Town & Country Planning Act 1990 (as amended)
Town & Country Planning (Development Management Procedure) (England) Order 2015 - Article 39

Lawful Development Certificate for a Proposed Use or Development

Development: We intend to install a new paint booth into unit 1 Dickenson Place, facility. To allow this to happen we have been advised by the paint booth manufacturer 3 off (Ducts) flues will need to be put through the roof of unit 1, we therefore request information to advise us if planning permission is required for the installations of these roof flues (Ducts) or not. This building is categorised as a light industrial unit. The requirements and dimensions for these flues (Ducts) has been defined by the manufacturer of the Spray booth as follows: -

Location: Unit 1 Dickinson Place Bognor Regis PO22 9QU

DWG.No. CD9725-01

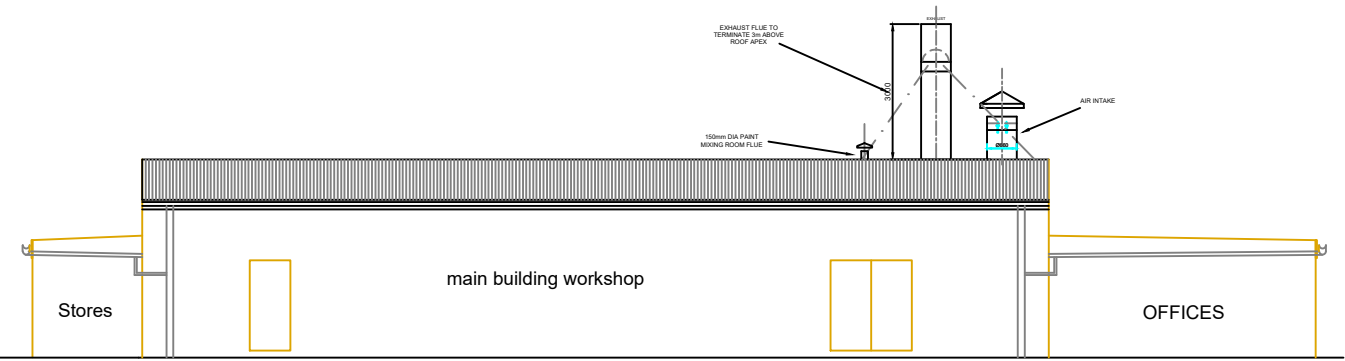
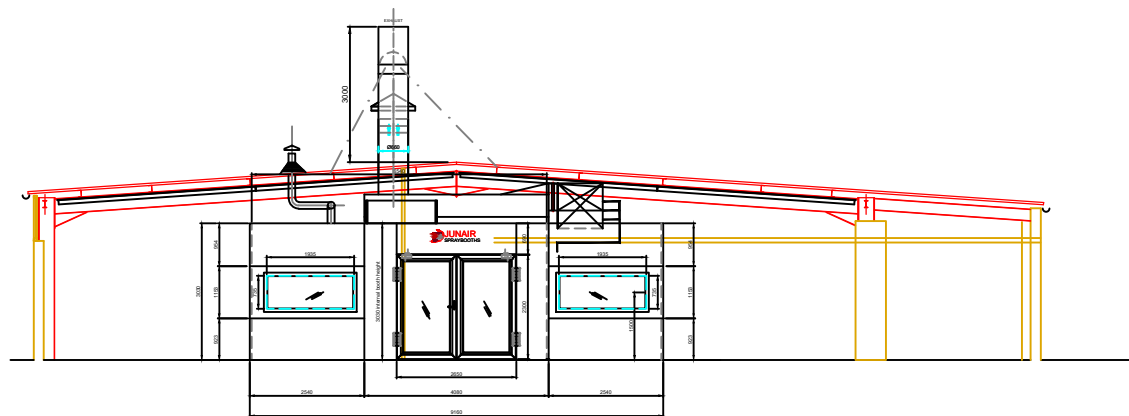
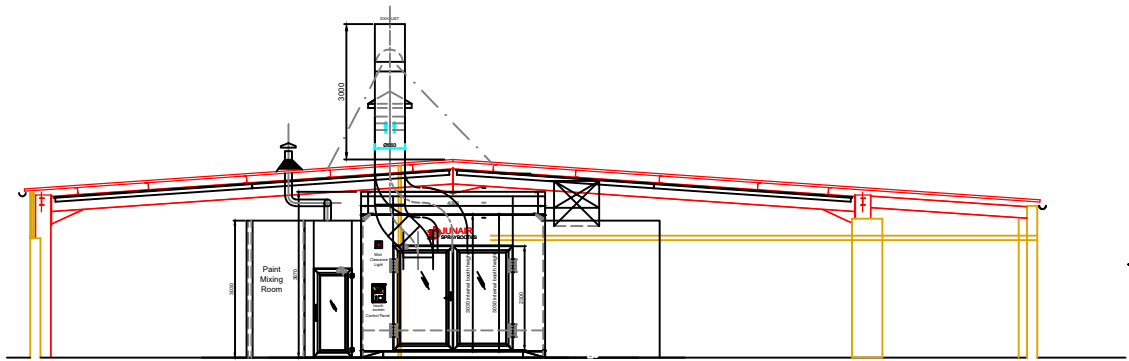
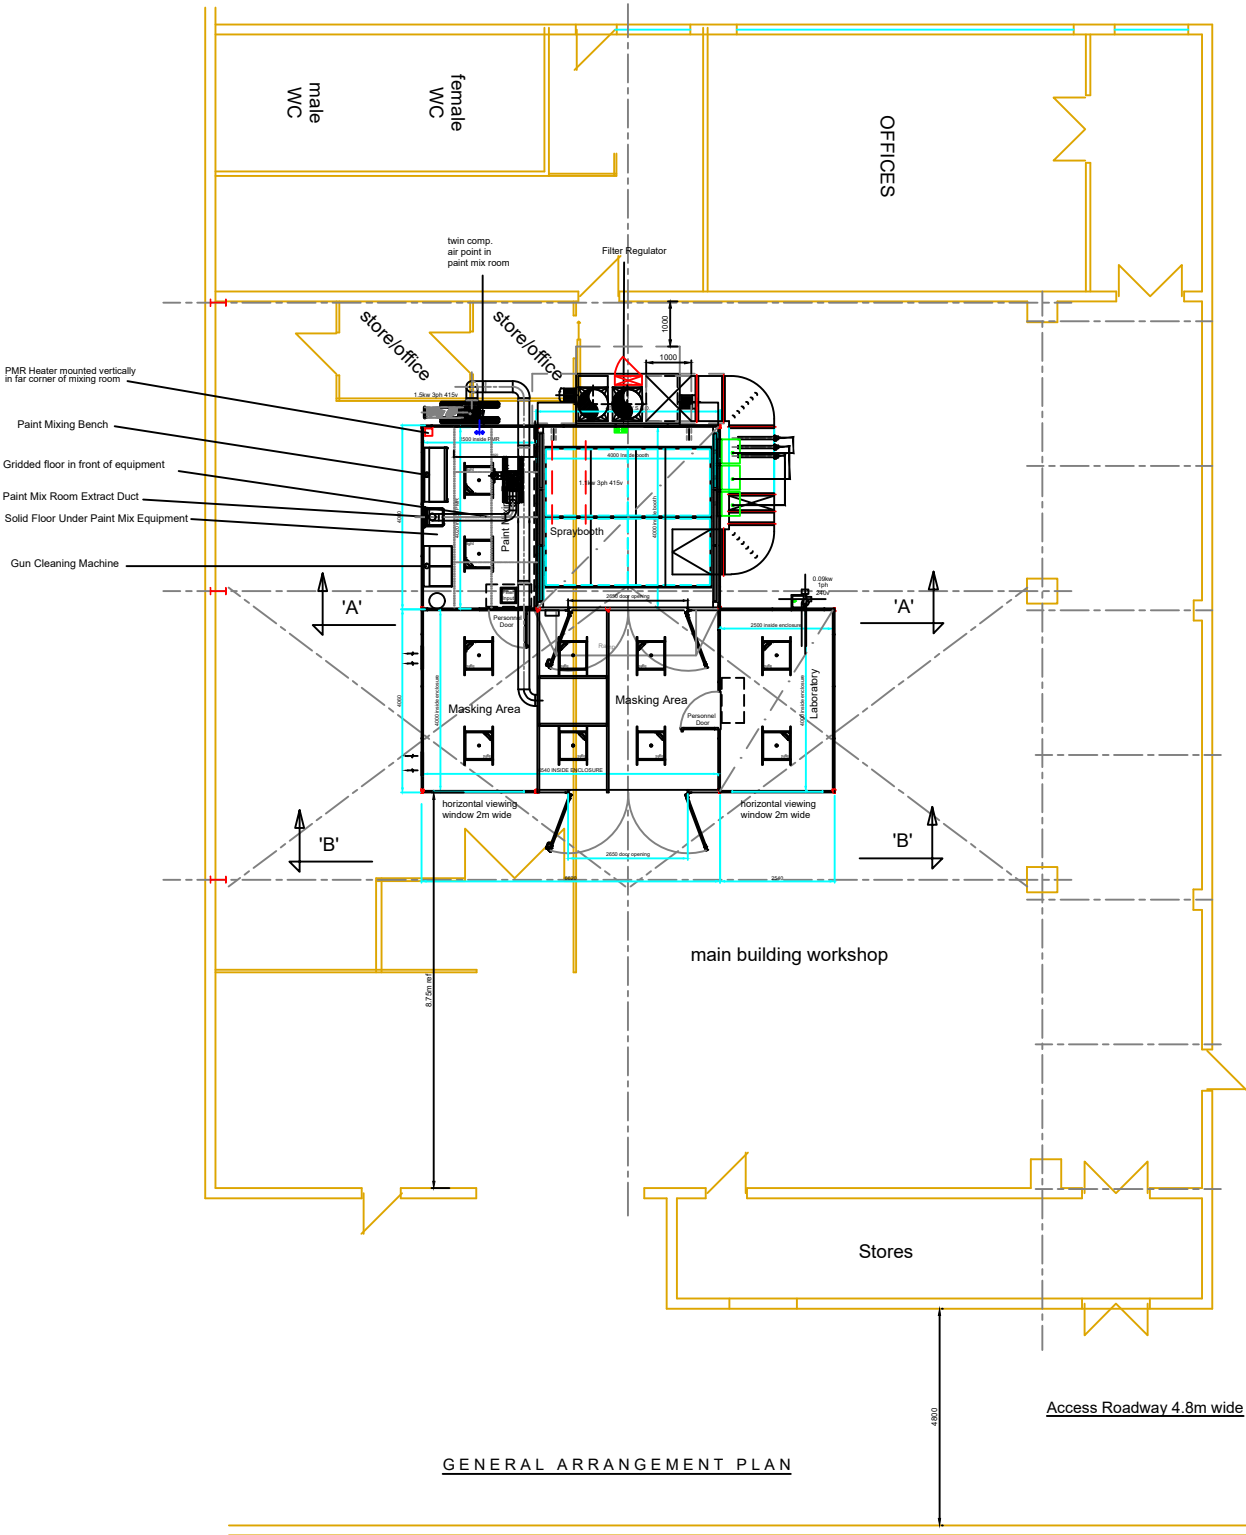
Please confirm the exact number of flues being proposed.

On the proposed floor plan and elevations, please show the position of the flues.
